Gatwick Northern Runway TR020005

PRINCIPAL AREAS OF DISAGREEMENT SUMMARY STATEMENT – DEADLINE 9 UPDATE

GATWICK NORTHERN RUNWAY PROJECT – PRINCIPAL AREAS OF DISAGREEMENT SUMMARY STATEMENT – DEADLINE 9 UPDATE

Project Code-Location-Discipline-Volume-Type-Unique Number
41700- XX -B- LLO- GA - 200178 P02

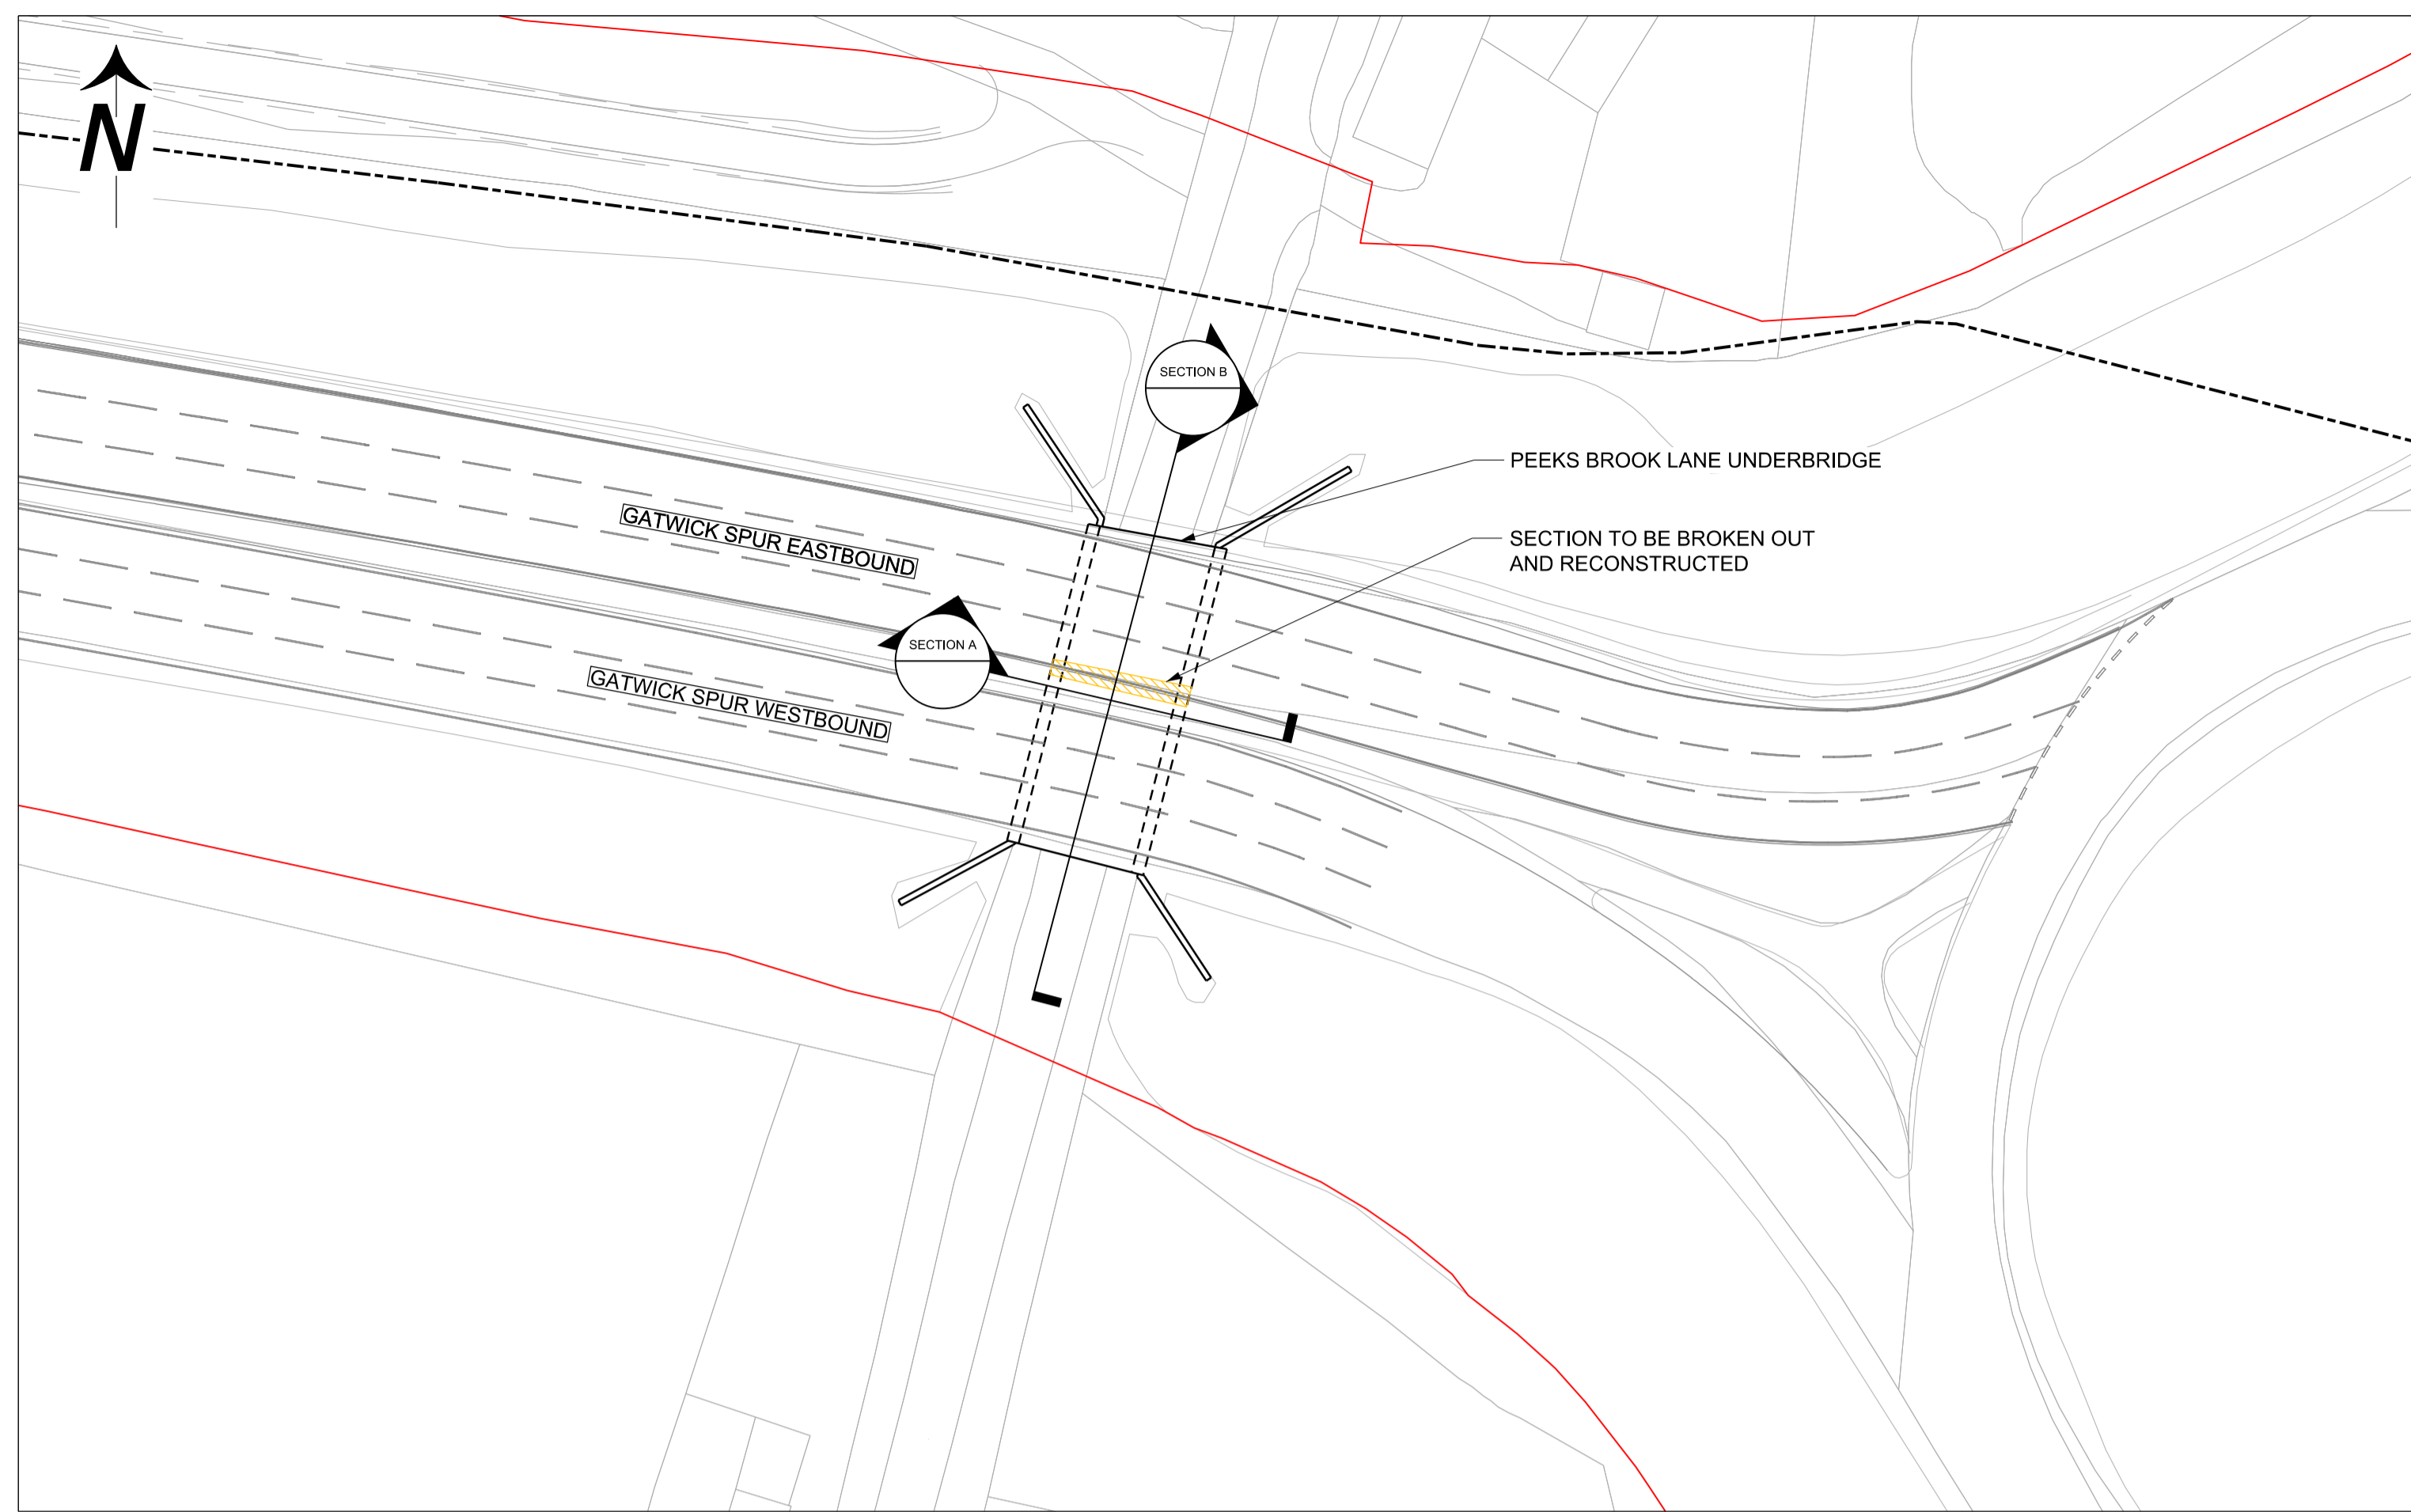
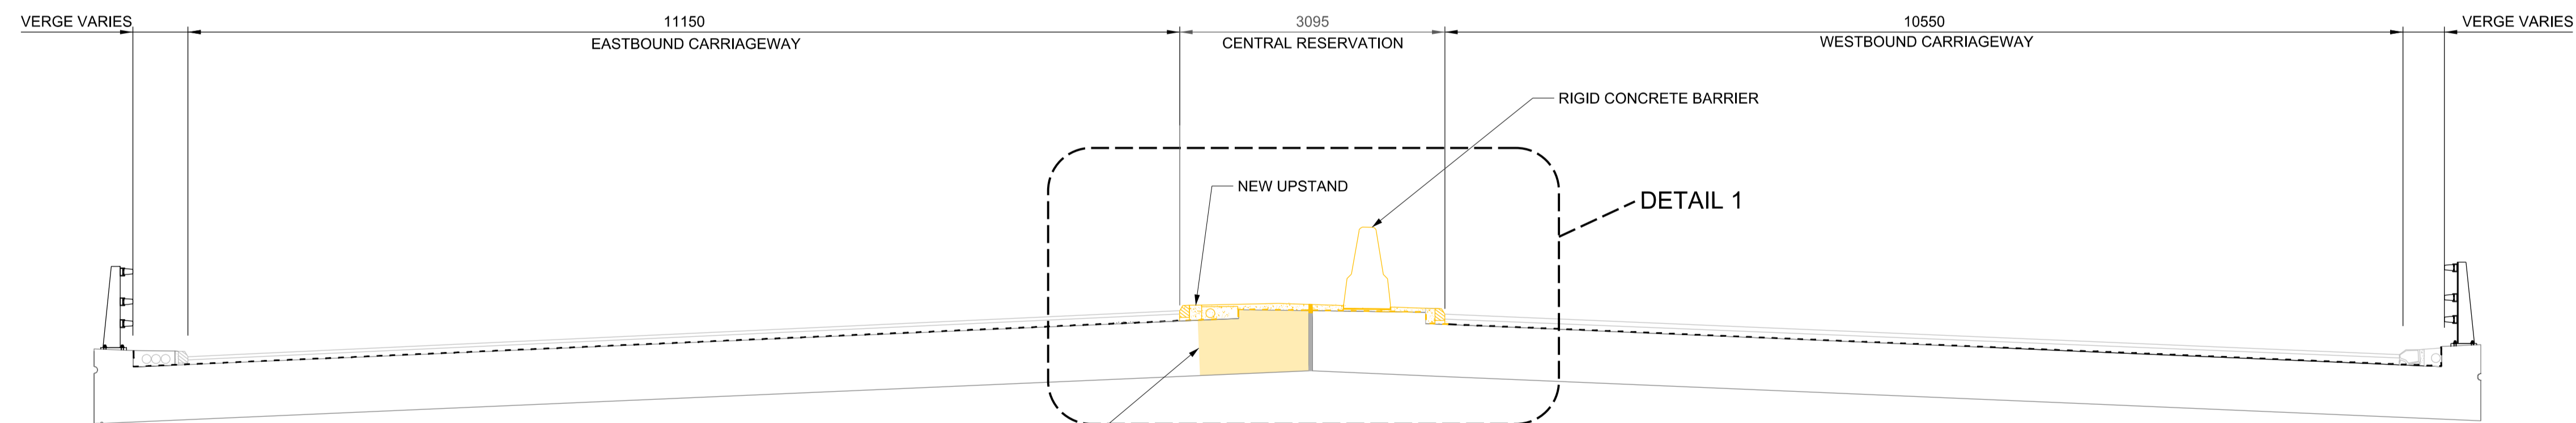
36 2.20.5.6	Structure Section Drawings (TR020005/APP/022) Drawing 41700-XX-B-LLO-GA-200178	This drawing provides a section through the Balcombe Road Underbridge. For the Gatwick Spur Eastbound carriageway Section C - C, this section denotes the presence of the noise barrier but does not indicate there being any structural parapet or edge restraint system on the parapet edge beam.	The Applicant is to confirm whether there is edge restraint being provided on this area and, if required, ensure that this drawing is updated. Updated position (Deadline 2): National Highways has reviewed the proposals by the Applicant and recommends the Applicant considers the following two options: If maintenance activities require operatives to access to the rear of the noise barrier, a pedestrian parapet system is to be installed on the structure to act as an edge restraint to minimise the risk of falling. If there are no maintenance activities required to the rear of the noise barrier, the noise barrier is to be repositioned on the structure to sit on the plinth, thereby restricting any unauthorised access to the structure. If this solution is considered by the Applicant, the relocation of the noise barrier may need to be considered as part of any acoustic assessments. Updated position (Deadline 5): National Highways notes the Applicant's response and requests that the Applicant provides details of any revision to the structure for comment in line with the strategy that National Highways articulated in its updated PADSS under item number 36 submitted at Deadline 2 [REP2-053]. Updated position (Deadline 9): National Highways can confirm that the Framework Agreement signed between both parties affords National Highways the necessary level of protection to ensure that this matter can be agreed for the purposes of the Development Consent Order Examination.		Yes Matter concluded at Deadline 9
